From: [REDACTED]
Sent: 28 September 2025 22:37
To: Planning
Subject: Planning application 3/2025/0688

Planning Application Reference No.: 3/2025/0688

Address of Development: Former Genus Site (Units 1-21 Mitton Road Business Park) Mitton Road Whalley BB7 9JY

Client <b>A I Land Ltd</b>		
Project <b>Proposed Alterations to Phase I Entrance at Mitton Road Business Park Whalley</b>		
Drawing Title <b>Existing and Proposed Site Plans</b>		
Scale <b>1:500 @ A2</b>	Date <b>Aug 2025</b>	Drawn <b>LFR</b>
<b>READ DESIGN LTD</b>		
<b>102 - 09 B</b>

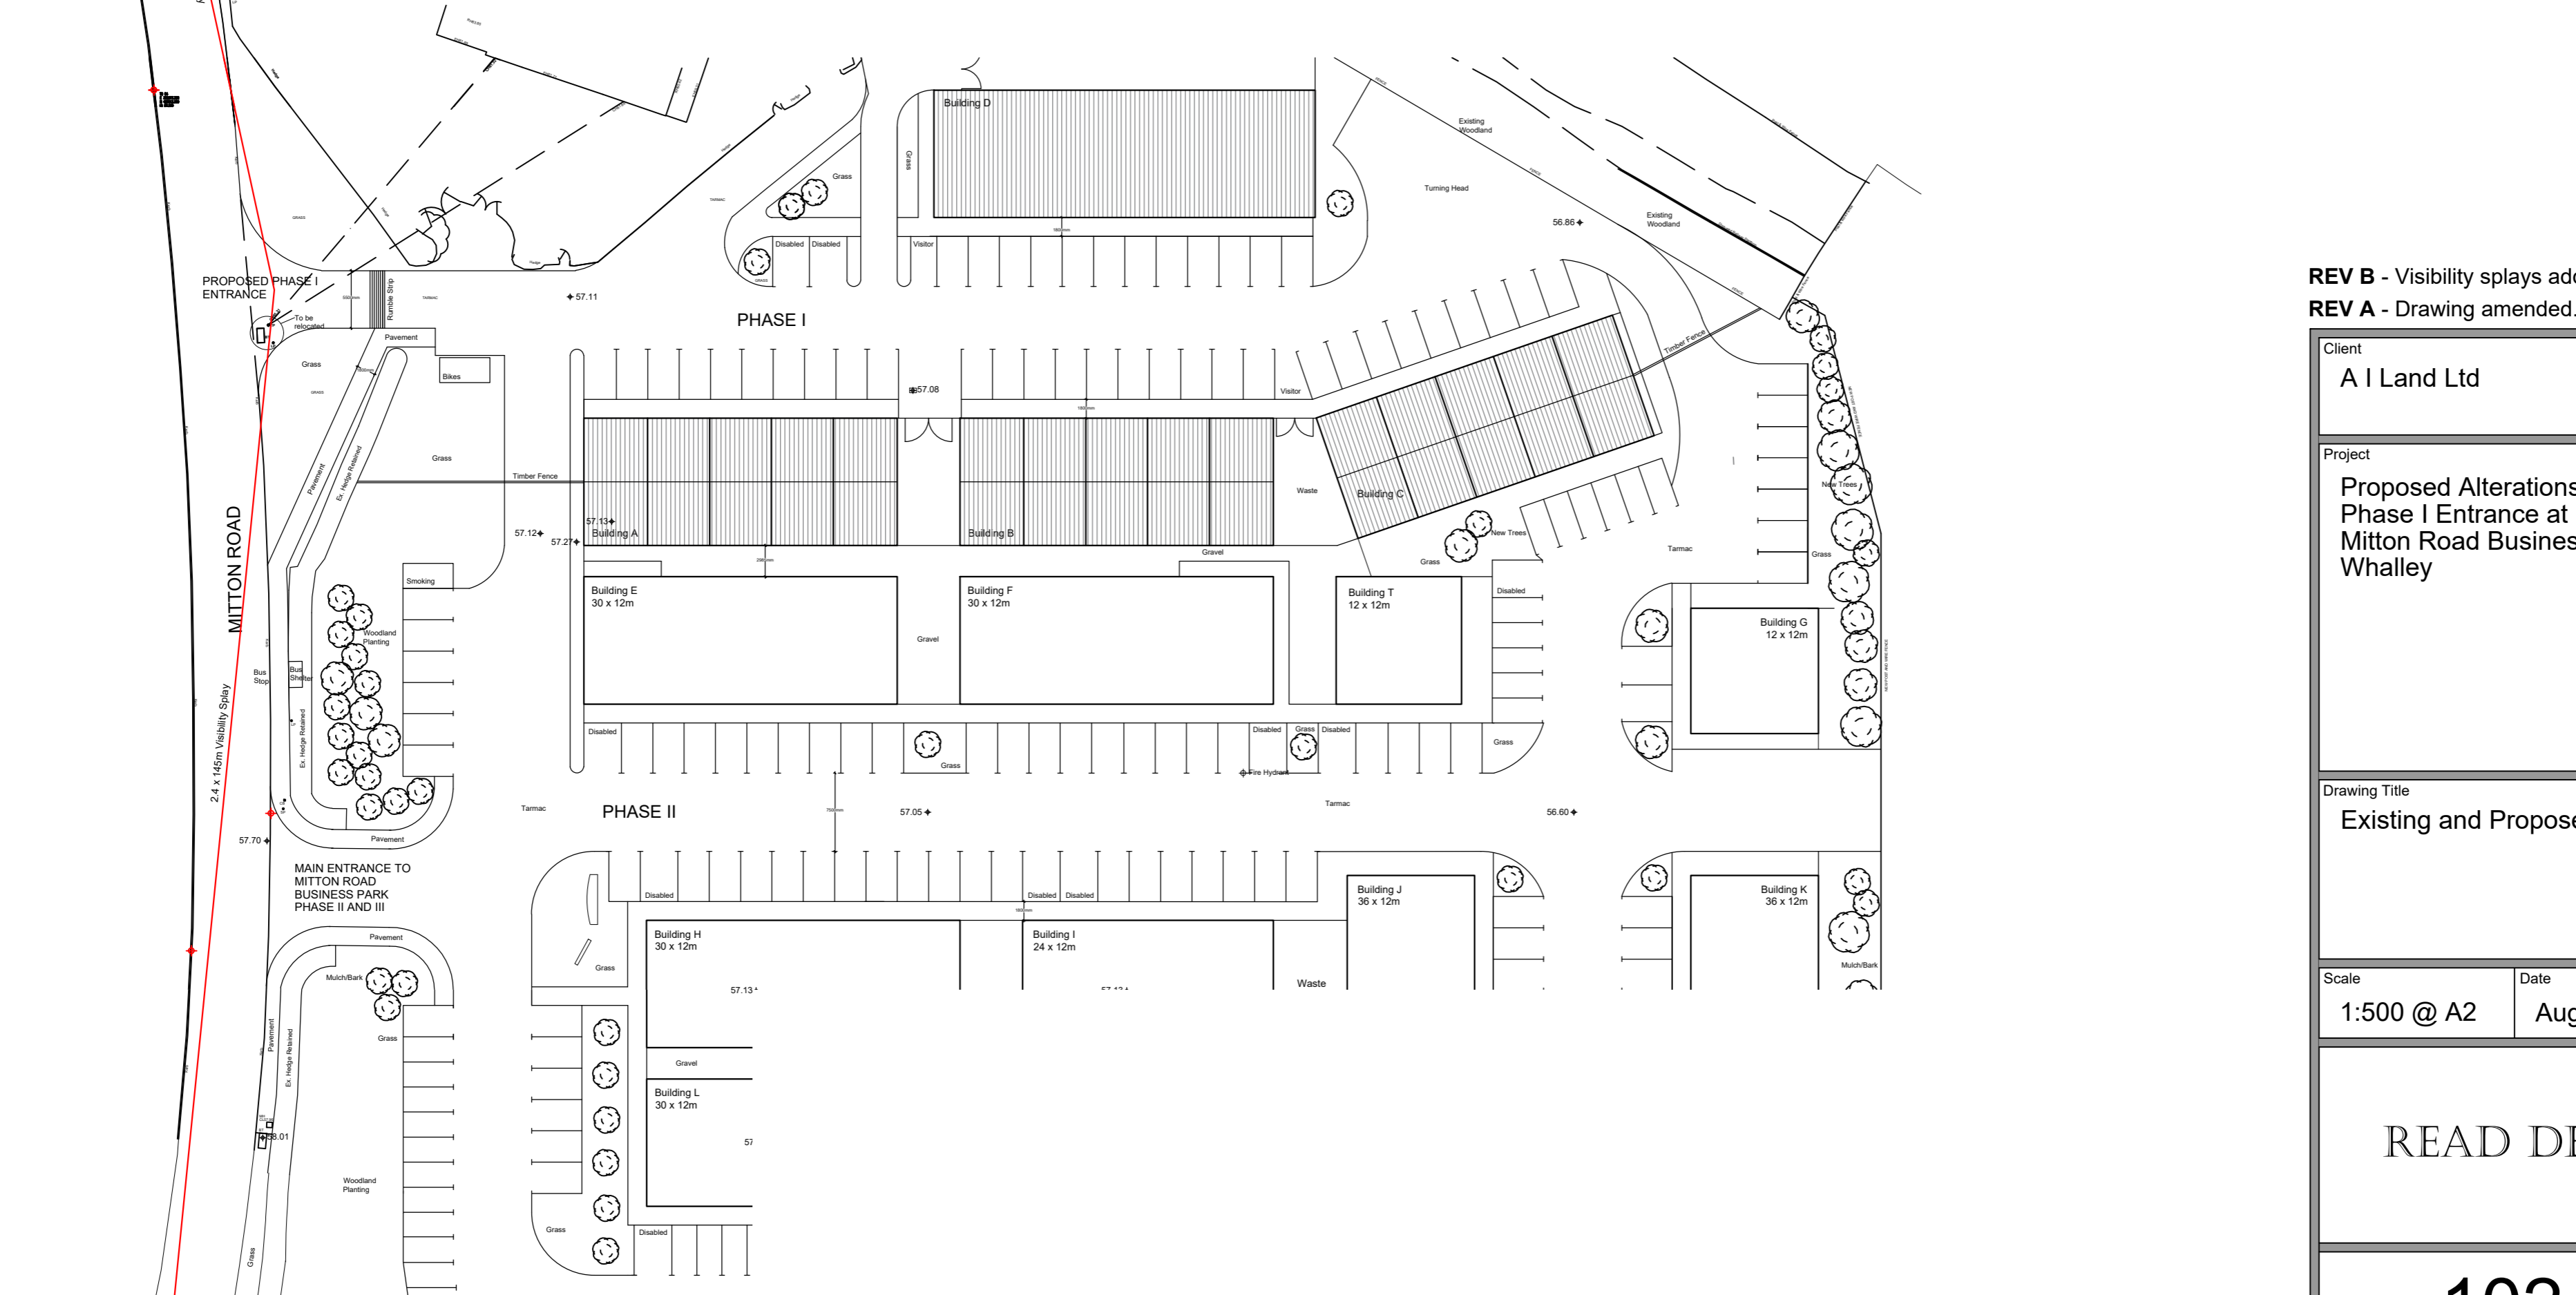
Secondly, the submitted plans registering how the current situation is are inaccurate, with omissions from the current situation. This would need correction before proper consideration could realistically be undertaken by the planning office.

With regard to the entrance itself [REDACTED] which give us concerns. [REDACTED] low to the ground and it wouldn't take much for the "rumble strip" to be changed to a sleeping policeman. Then that car would never be able to exit at all. This physical barrier of whatever variety on the surface of the road, will exacerbate the increase in flow of the surface water experienced since the estate was created. It will restrict water flow to the road (where we were informed was the only drain area for this part of the estate). We already are having to consider putting in extra drainage in the front garden of the house due to the water logging that always occurs after a period of rain together with damage to the tarmac.

The [REDACTED] is a [REDACTED] [REDACTED] that we fear would have considerable difficulty getting out of the driveway and then out the exit as proposed, especially with the cars that tend to [REDACTED] (which I presume will be a greater issue with reduced parking available).

I would also ask if there has been any data collected or estimated as to the increase in traffic going past the [REDACTED] in and out of the emergency exit when the phase one becomes cut off from the other phases? All customers, owners and suppliers will then be using the one exit in and out. Is there any consideration of what will happen to deal with larger or articulated vehicles arriving from suppliers to the units within phase one and their turn around and waiting? I am a [REDACTED] at the [REDACTED] [REDACTED] I need to leave immediately if called upon and even a slight delay can be significant. This is especially true on a Saturday day time or early hours if vehicles are parked up close to the end of the drive.
